Submission on Cathodic Protection

The Yorkshire and Humber (CCS Cross Country Pipeline) Development Consent Order

CAMBLESFORTH MULTI-JUNCTION LOCATION PLAN
APFP REGULATION 5(2)(0)
PINS REFERENCE No: EN070001
DOCUMENT REFERENCE 2.24

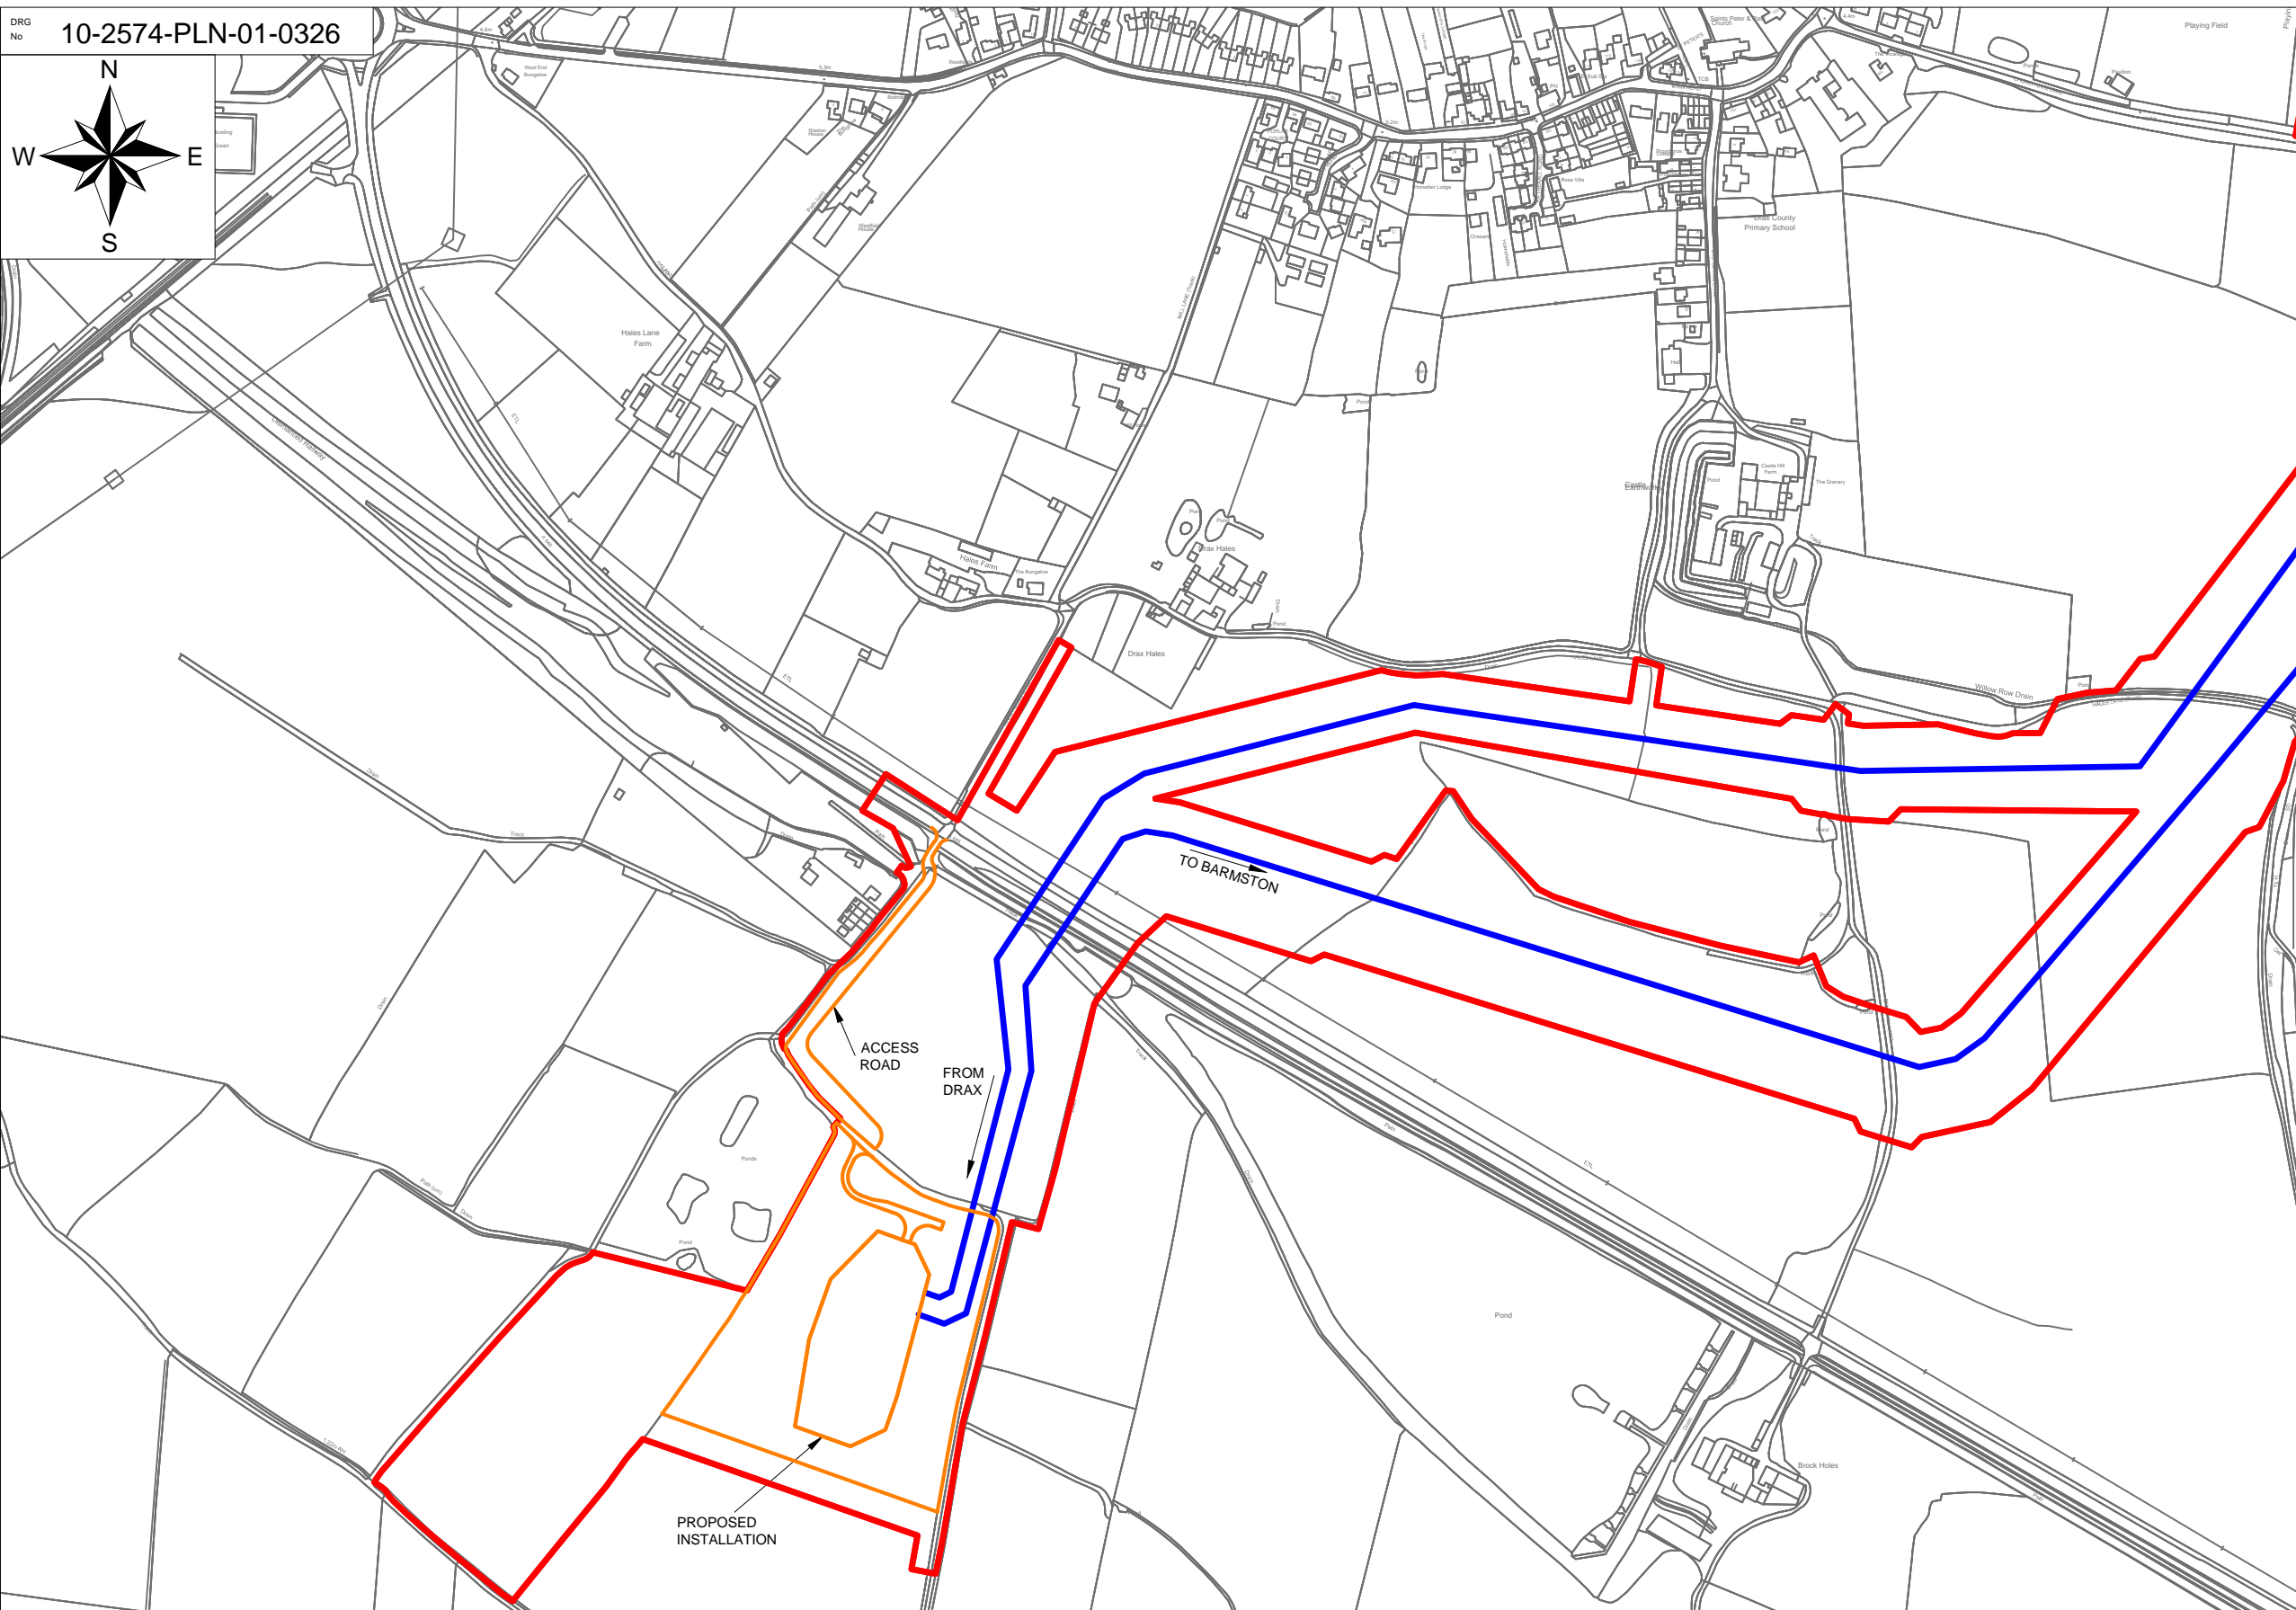
- 2.1.1 The land is shown on the land plans² (document reference 2.1) within the Order limits as plot number 75. This plot forms part of the access road to be created from Wade House Lane to the multi-junction. The plot is included in the book of reference for **Permanent type 1**, as well as **Temporary-general** and **Temporary-drainage**. This means that the freehold title is sought through the compulsory acquisition powers in the DCO. **No further or different compulsory acquisition powers are sought as a result of the CP apparatus.**

- 2.1.2 The CP ground-bed would be located directly adjacent to, or beneath, the access road. The transformer rectifier kiosk would be located within the multi-junction as has always been the case. **All of the CP apparatus now proposed to be placed in this location outside the AGI compound will be within the current order limits and the current plot 75.**

- 2.2.1 The only amendment to the application, is in the description of the authorised development, at Schedule 1 of the draft DCO. **No new work number or change to the works plan is required.** A change to Work No. 4C is required as follows (in red and ~~strikeout~~):

“**Work No. 4C** – A road from A645 / Wade House Lane junction up to and including the carbon dioxide facility at Camblesforth Multi-junction (Work No. 4A) including any splays, gates, fencing, drainage, drainage attenuation and interceptors, piped culverts, utilities, associated ducting, ~~and~~ landscape works **and cathodic protection apparatus including buried cathodic protection groundbeds and anodes, buried electrical wiring and ducts and test posts.**”

TITLE  
 TOLLINGHAM BLOCK VALVE PERMANENT VEHICULAR ACCESS (SKIFF LANE)  
 APFP REGULATION 5(2)(0)  
 PINS REFERENCE NO. EN070001  
 DOCUMENT REFERENCE 2.56

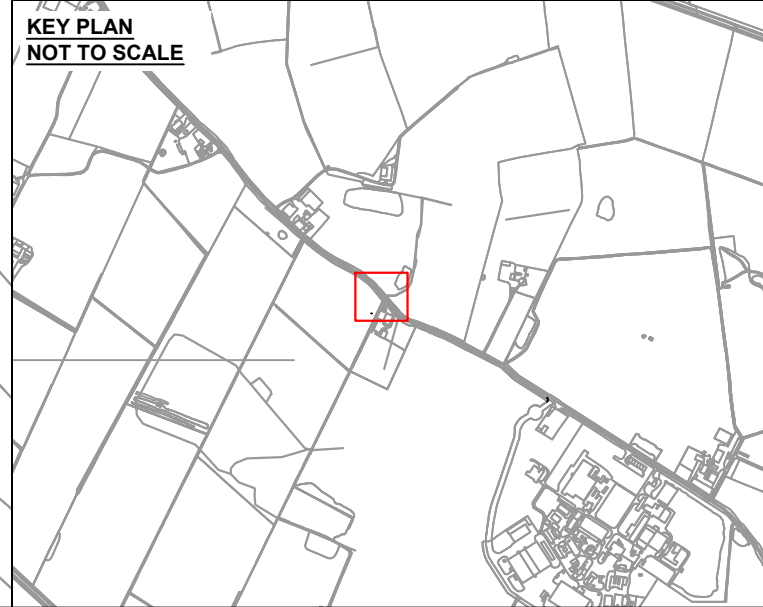
- 3.1.1 The land is shown on the land plans³ (document reference 2.1) within the Order limits as plot number 581. This plot forms part of the access road to be created from Skiff Lane to the block valve. The plot is included in the book of reference for **Permanent type 1**, as well as **Temporary-general** and **Temporary-drainage**. This means that the freehold title is sought through the compulsory acquisition powers in the DCO. **No further or different compulsory acquisition powers are sought as a result of the CP apparatus.**
- 3.1.2 The CP ground-bed and the transformer rectifier kiosk would be located directly adjacent to, or beneath, the access road. **All of the CP apparatus now proposed to be placed in this location outside the AGI compound will be within the current order limits and the current plot 581.**

- 3.2.2 Fencing or barriers are required only in this location as here the transformer rectifier and cabinet may be outside of the AGI, albeit on land which National Grid will own.

- 3.2.1 The only amendment to the application, is in the description of the authorised development, at Schedule 1 of the draft DCO. **No new work number or change to the works plan is required.** A change to Work No. 6C is required as follows (in red and ~~strikeout~~):

“Work No. 6C - A road from Skiff Lane up to and including the carbon dioxide facility at Tollingham Block Valve (Work No. 6A) including any splays, gates, fencing, drainage, drainage attenuation and interceptors, piped culverts, electricity kiosk, utilities, associated ducting, and landscape works **and cathodic protection apparatus including buried cathodic protection groundbeds and anodes, buried electrical wiring and ducts, test posts and above ground transformer rectifier with cabinet and guard rail.”**
